From: Planning
Subject: FW: 3/2020/0911

From: Dunderdale, Chris <Chris.Dunderdale@lancashire.gov.uk>
Sent: 16 December 2020 12:02
To: Adam Birkett <Adam.Birkett@ribblevalley.gov.uk>
Cc: Hargreaves, Hilary <Hilary.Hargreaves@lancashire.gov.uk>; Gregg, Robert <Robert.Gregg@lancashire.gov.uk>; Planning <planning@ribblevalley.gov.uk>
Subject: RE: 3/2020/0911

I've now reviewed the above application and I've the following observations to make with regard to the applicant's flood risk assessment:

P1	ISSUED FOR INFORMATION	SD	SJR	29.10.21
Rev	Details	Drawn By	Checked By	Date

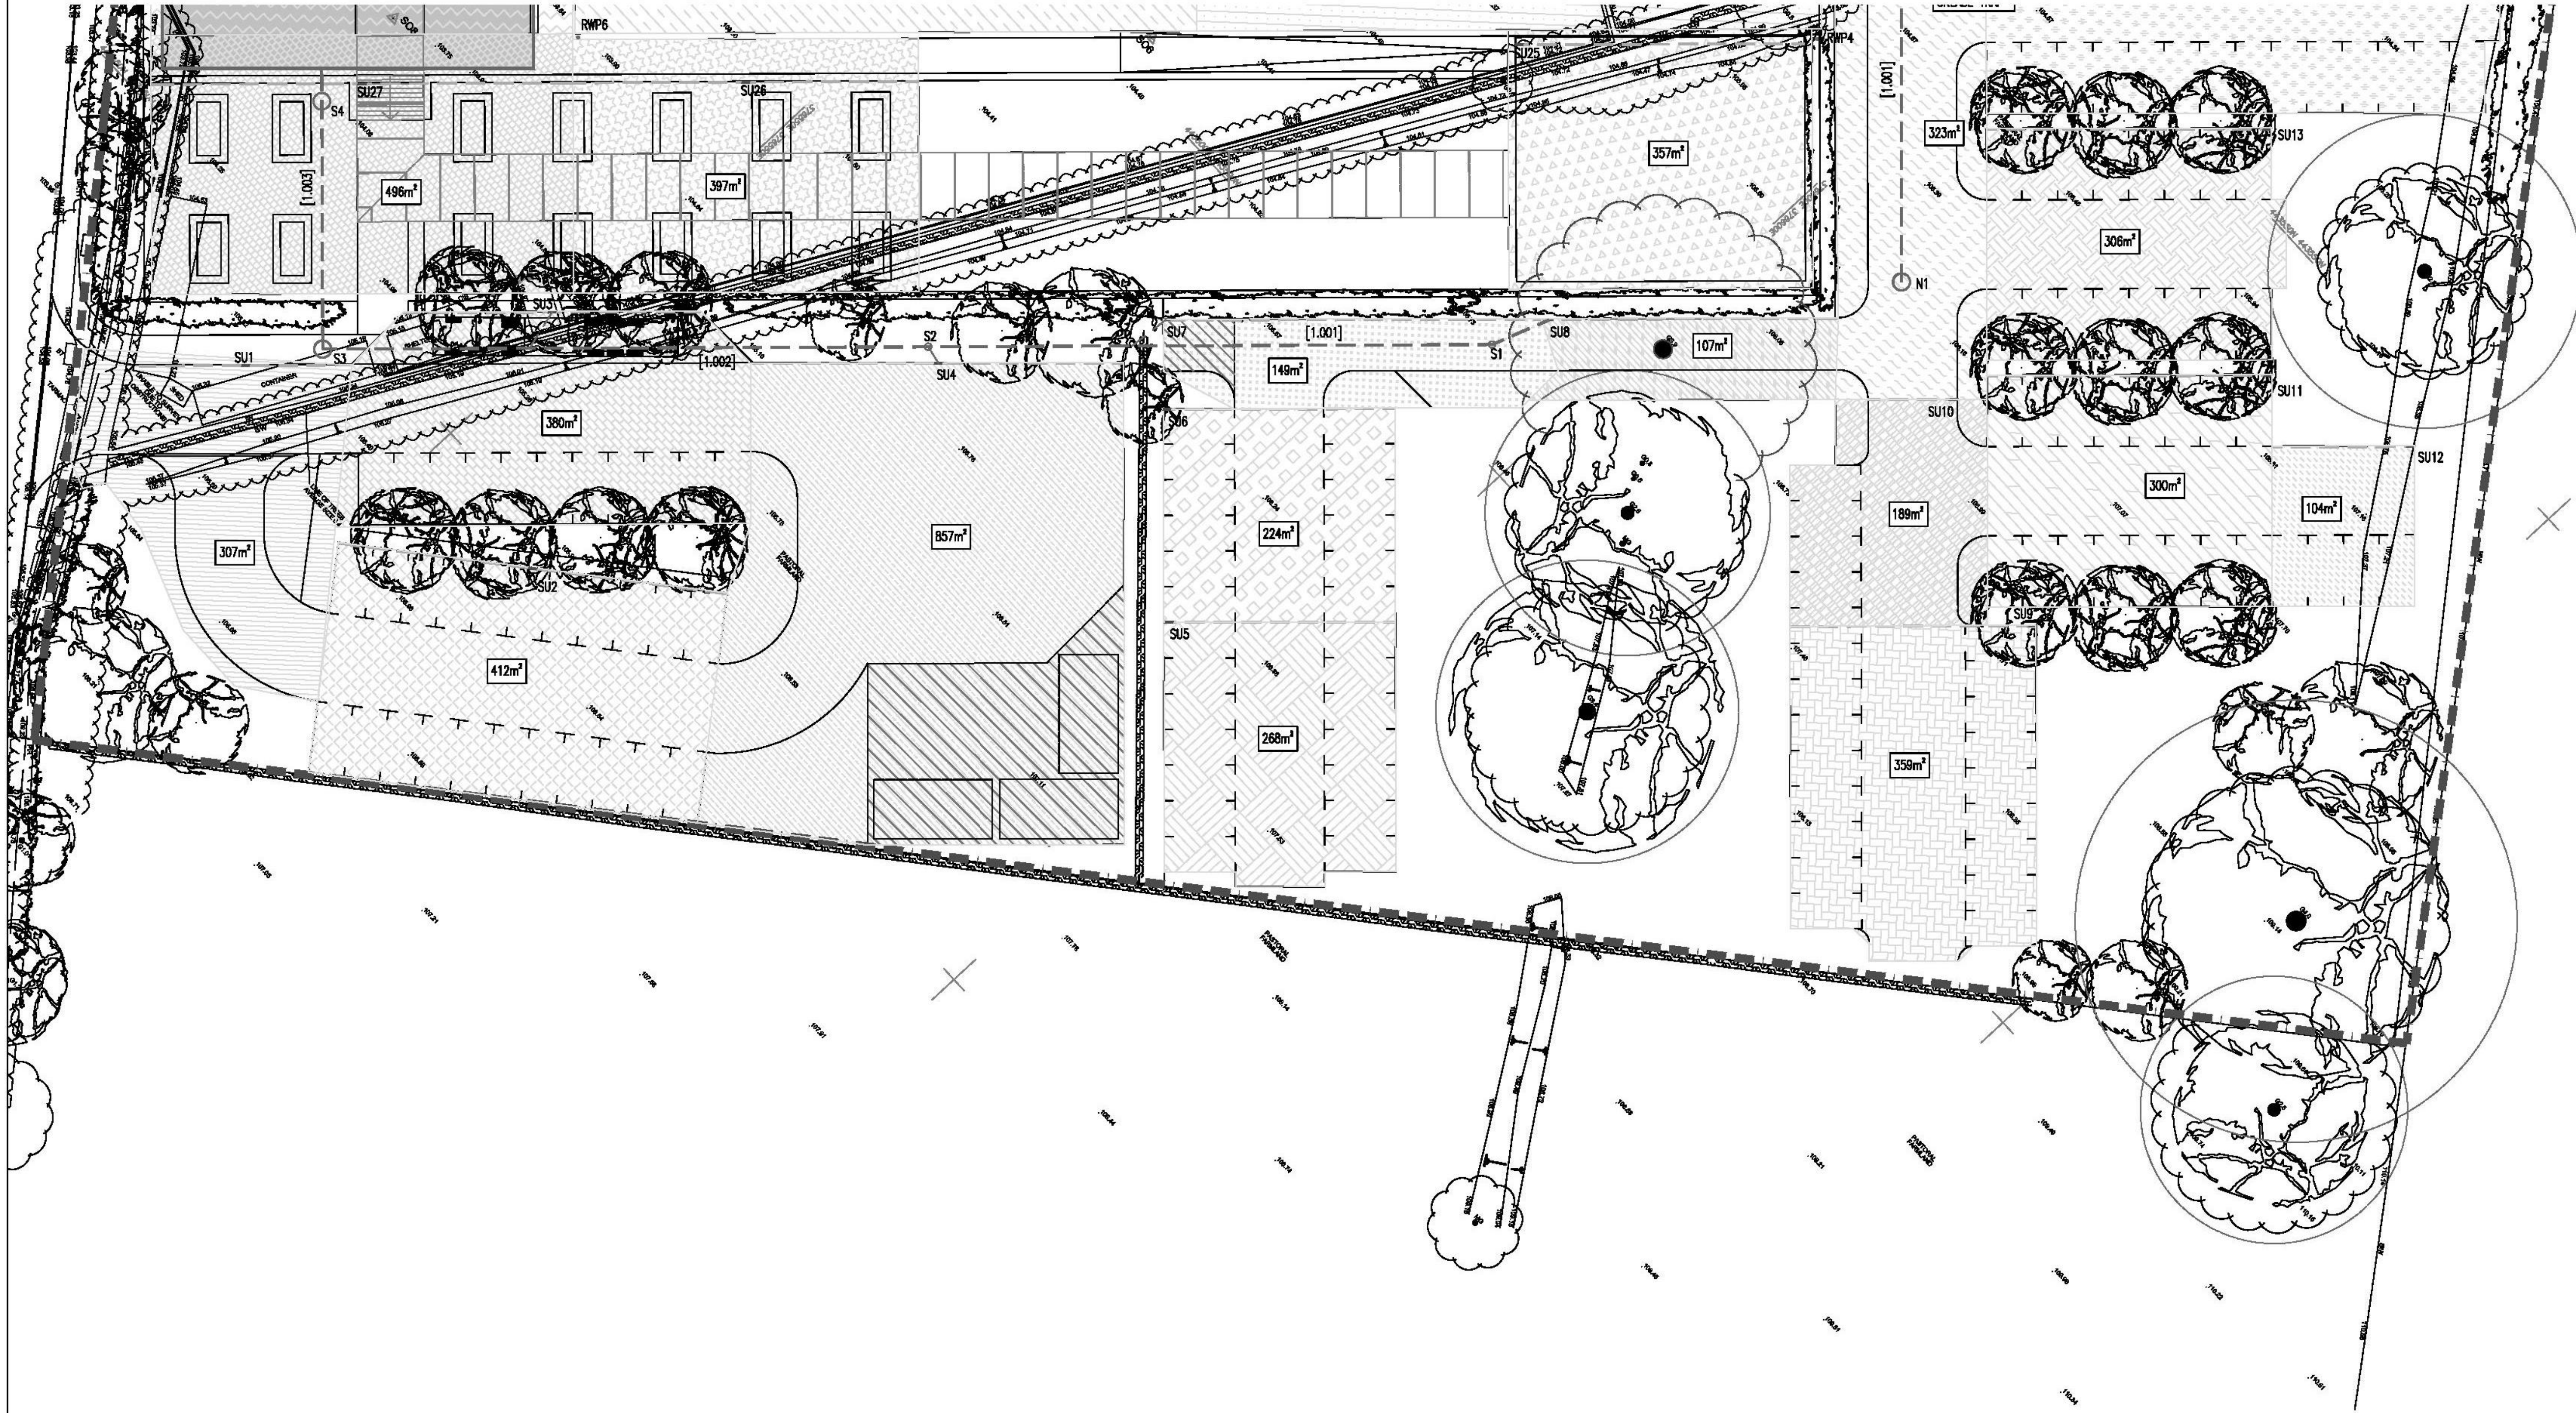
- **Appendix F - drawing no. 10301-101 P1:** I note the applicant has set out their indicative drainage proposals on drawing no. 10301-101 P1 to show how surface water could be

safely managed over the lifetime of the development. That drawing is however incomplete as it fails to include details of the measures needed to rectify the flooding on Worston Road and it also fails to include details of the existing on-site drainage and private sewer network under Clitheroe Road. Please can you raise this with the applicant and ask for the outstanding information to be appended to the drawing, along with details of all pipe/structure references, dimensions and design levels so the drawing can be cross referenced with the supporting flow calculations.

- **Appendix G – surface water flow calculations:** I note the applicant has provided some preliminary surface water flow calculations to support their indicative drainage layout plan. However, for the same reason as above, I'd recommend for the drainage model to be expanded to also include the existing on-site drainage and private sewer network under Clitheroe Road. I'd also recommend for the drainage network to be re-modelled with a surcharged outfall unless it can be demonstrated that a free flowing outfall can be achieved. Please can you raise these points with the applicant and ask for them to be considered further. As noted above, we won't be able to cross reference the calculations with the drainage layout plan until all relevant pipe/structure references, dimensions and design levels have been appended to the drawing.
